Response to Submissions

Section 96(1A) Modification to SSD 7917 for Proposed Warehouse/Distribution and Industrial Facility

Lot 3, Horsley Drive Business Park (Lot 5 in DP 1212087)

DRAWING NUMBER ISSUE
VI-WSPT-S96-003 B

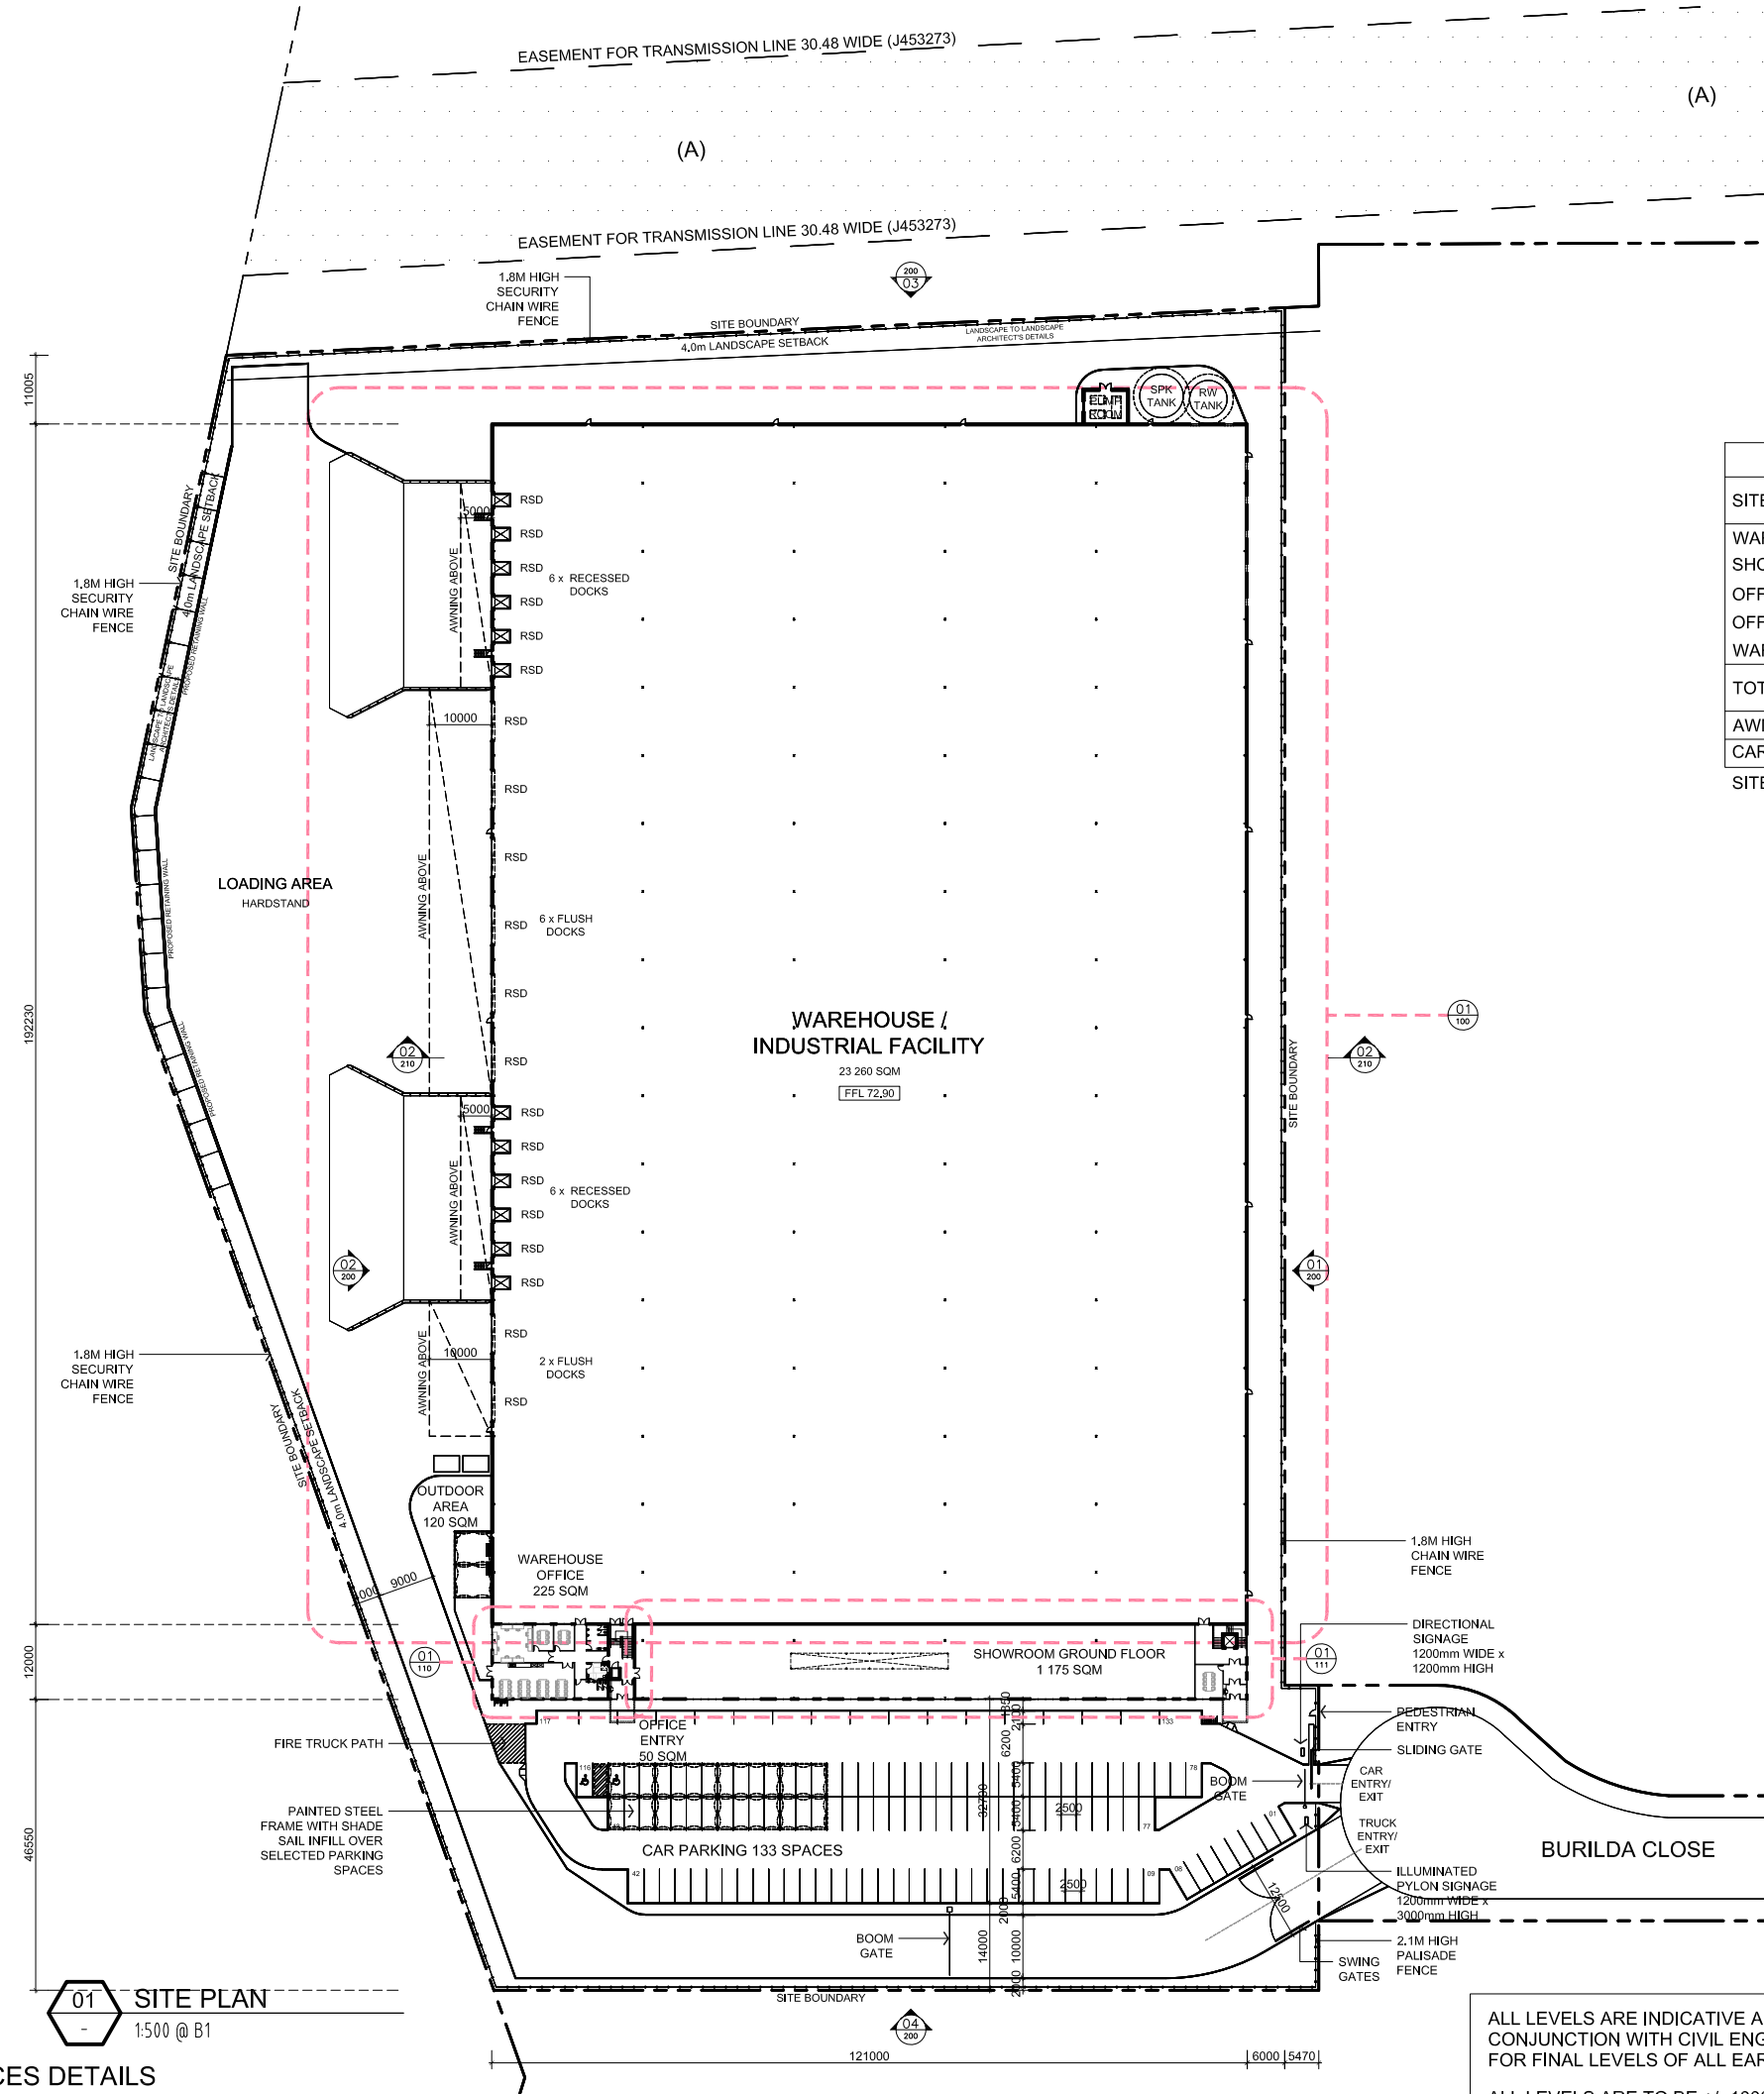
- ***Clarification of the hours of operated assessed against the sleep disturbance criteria in the acoustic report;***
- *Modification of the acoustic report to show construction hours as 7am-6pm Monday to Friday and 8am-1pm Saturday; and*
- *Modified site plans showing the waste storage area being covered, bunded and drained to sewer.*

In relation to waste storage, mobile waste bins with lids will prevent rubbish being blown around. Further, no liquid wastes will result from the proposed operations,

and therefore there is no need to drain to the sewer. Accordingly, no changes to the previously-submitted Site Plan are proposed.
<p>c) Development Planning</p> <p><i>The showroom component is required to be ancillary to the proposal and not the dominant use.</i></p> <p><i>Council recommends that the substantially the same development test should be applied to the proposed modification application.</i></p> <p><i>Council notes that no landscape plan appears to be provided as part of the modification application.</i></p> <p><i>Council requests that an amended landscape plan shall be provided which demonstrates landscaping with established large trees is provided on site in particular within the front setback in order to soften the hard stand areas.</i></p>	<p>The proposed showroom will be ancillary and subservient to the primary use of the site for warehousing, distribution and industry. The showroom comprises a relatively minor proportion of the total floor space of the development, and will not be capable of operating independent of the warehouse.</p> <p>As described within the Planning Report submitted in support of the S96 Modification, the proposal as modified will be substantially the same as the development for which consent was originally granted. This is confirmed on the basis of the following:</p> <ul style="list-style-type: none"> ▪ Primary Land Use – The warehousing and distribution use of the site is not proposed to change. ▪ Gross Floor Area – The overall Gross Floor Area is sought to increase by 2,600m². ▪ Height – The height of the building is a minor increase from 10m to 11.5m. ▪ Car Parking – All facilities shall provide sufficient car parking as per the Concept Plan controls. ▪ Setbacks – Sufficient setbacks shall be maintained to ensure landscaped buffers can be achieved and separation is such that the visual amenity of the public domain is not compromised. ▪ Traffic Generation – Traffic generation shall not increase beyond that originally modelled for SSD 7917. ▪ Car Parking – Car parking provided will be compliant with rates per SSD 7917. <p>For these reasons, the proposal as modified is considered to satisfy the 'substantially the same test' as required by S96(1A) of the EP&A Act.</p> <p>Modified Landscape Plans have been provided at Appendix 3. As shown within the Landscape Plans, planting has been provided adjacent to the northern, southern and eastern site boundaries and will include semi-advance (45L) or advanced (100-200L) specimens. Landscaping has also been proposed adjacent to the western boundary and will include 200mm stock. It is noted that adjacent to the western boundary larger pot sizes would be difficult to install and plants would not establish as well due to the planting bed being located behind a crib wall.</p>

DRAWING TITLE
SHOWROOM
GROUND FLOOR &
FIRST FLOOR PLANS

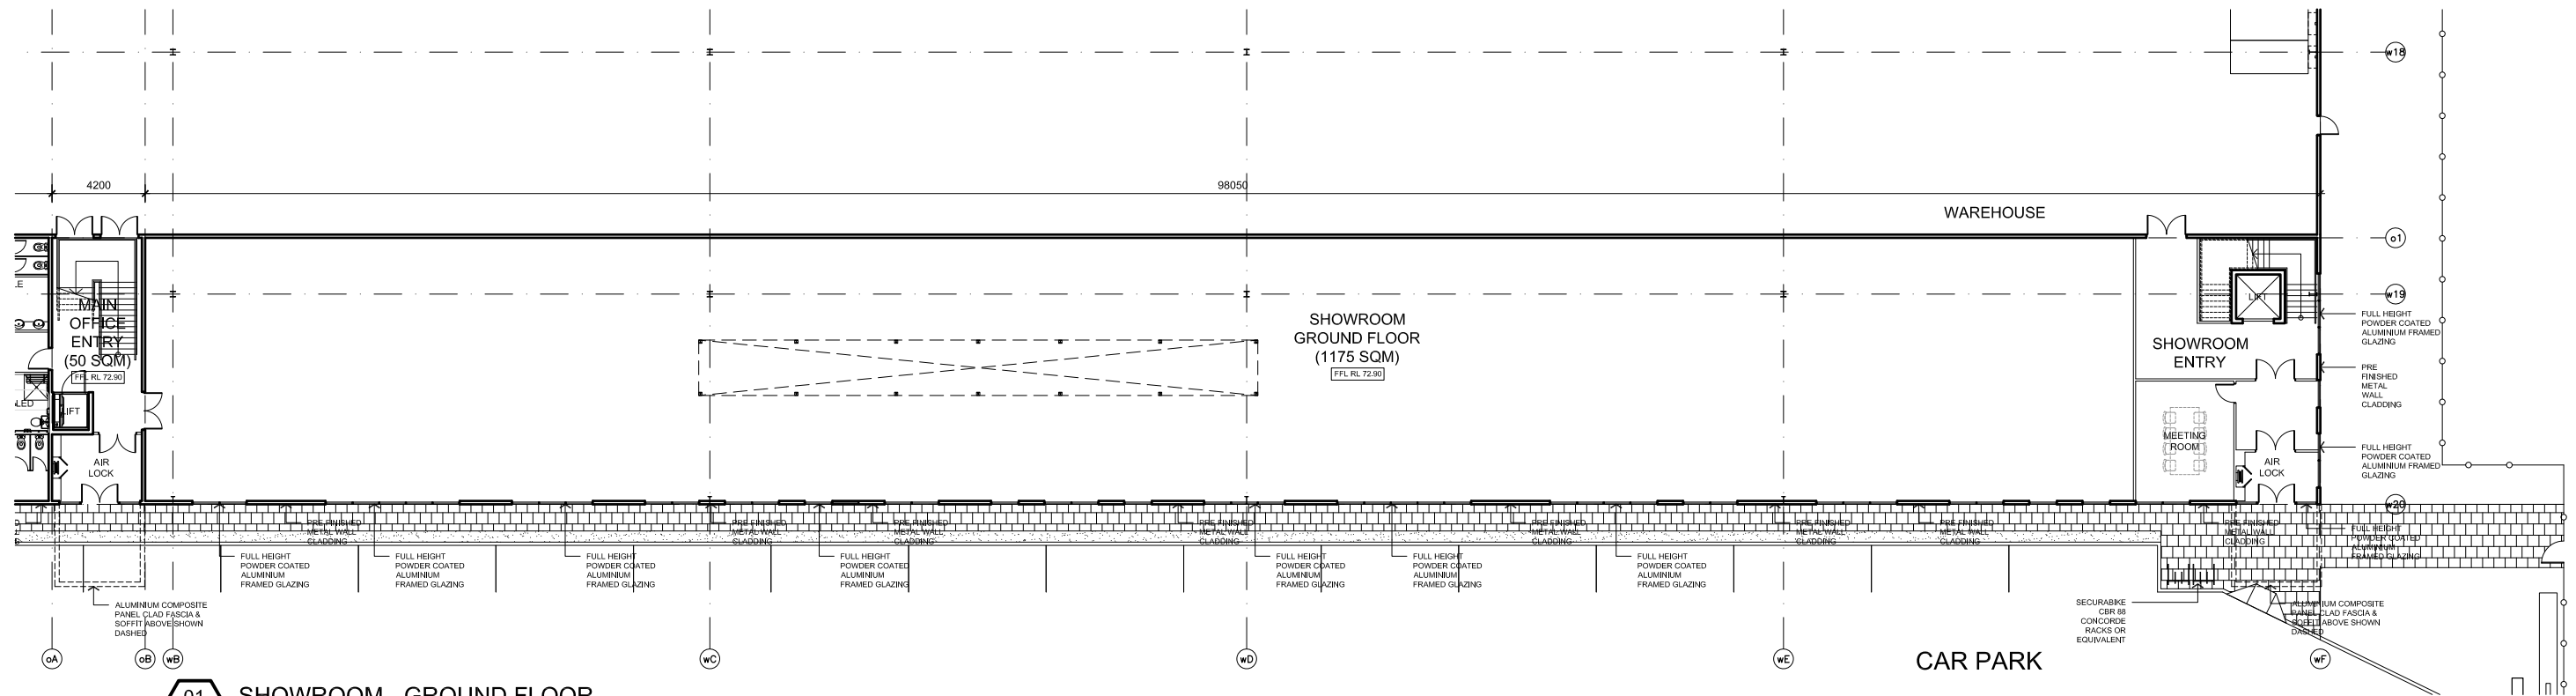
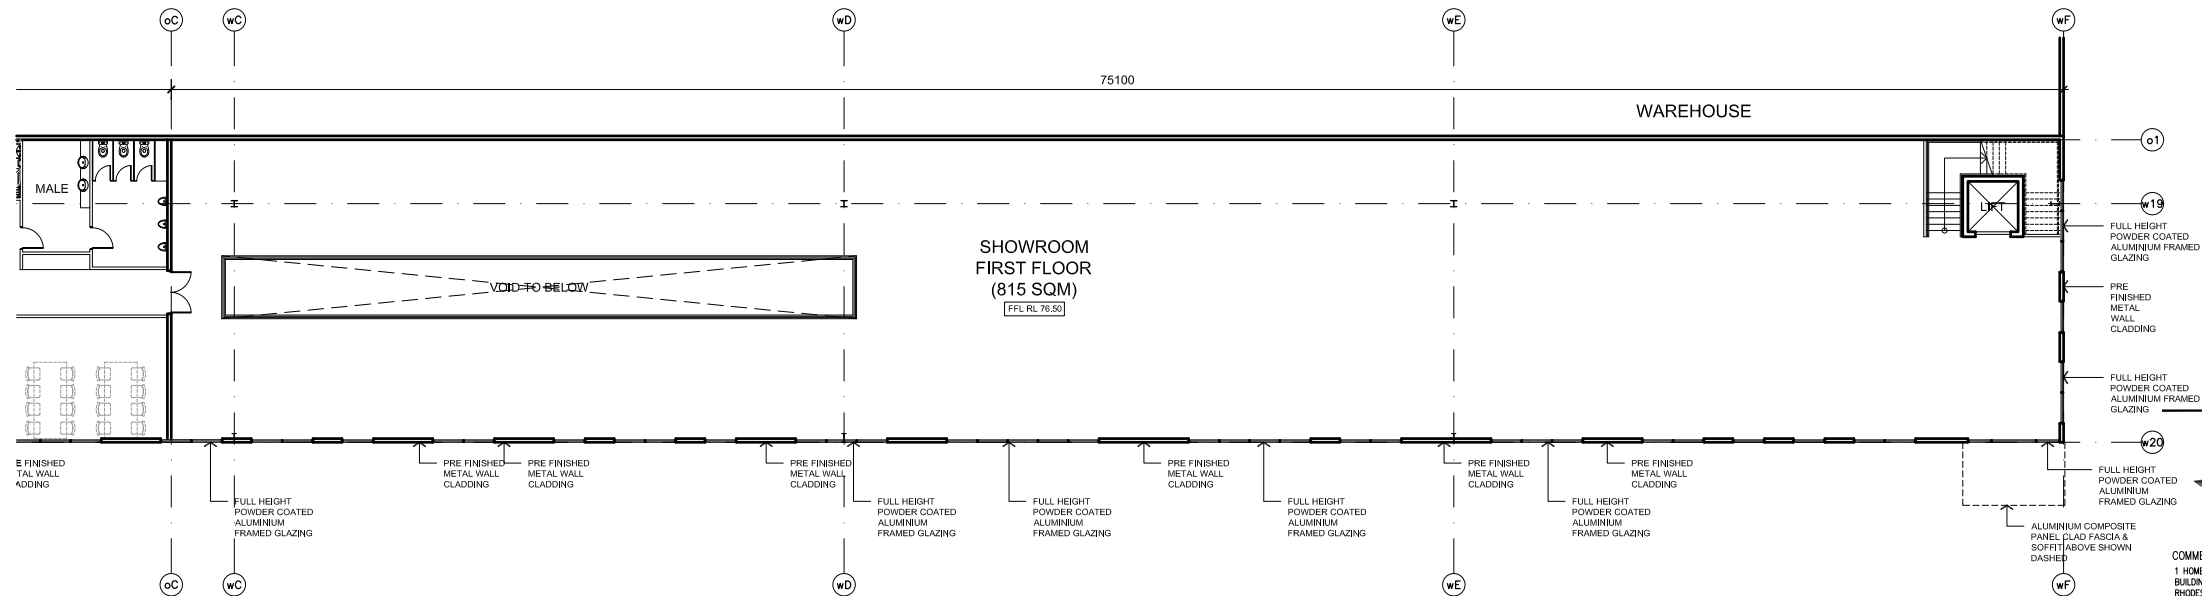
2. Fairfield City Council	
a) Traffic Management <i>There are no issues raised with the construction of one warehouse and the number of car parking spaces proposed as it complies within the minimum requirement for parking. Further, Council seeks to be satisfied that there is sufficient car parking provided on site in order to meet the parking demand for the showroom.</i>	<p>As noted in Council's response, the proposed car parking for the warehouse complies with the number of spaces required pursuant to Council's controls.</p> <p>As per the Traffic Report submitted in support of the S96 Modification application, the proposed showroom will be utilised for the display of products to the trade industry/clients whom would arrive to the site by invitation only. The showroom would not be open to the public. Accordingly, visitors to the showroom would be strictly managed by site operations, and would generate demand commensurate with that of the general warehouse operations. Based on the parking rates adopted within the original DA Traffic Report, 1 space would be required per 200m² showroom GFA</p>

equating to a requirement of 4 spaces for the showroom. The total car parking proposed for the facility includes 4 spaces for the showroom as well as an overall surplus of 3 spaces. Accordingly, the Traffic Report confirms that adequate on-site parking has been provided to accommodate the demand generated by all components of the facility, including the showroom.
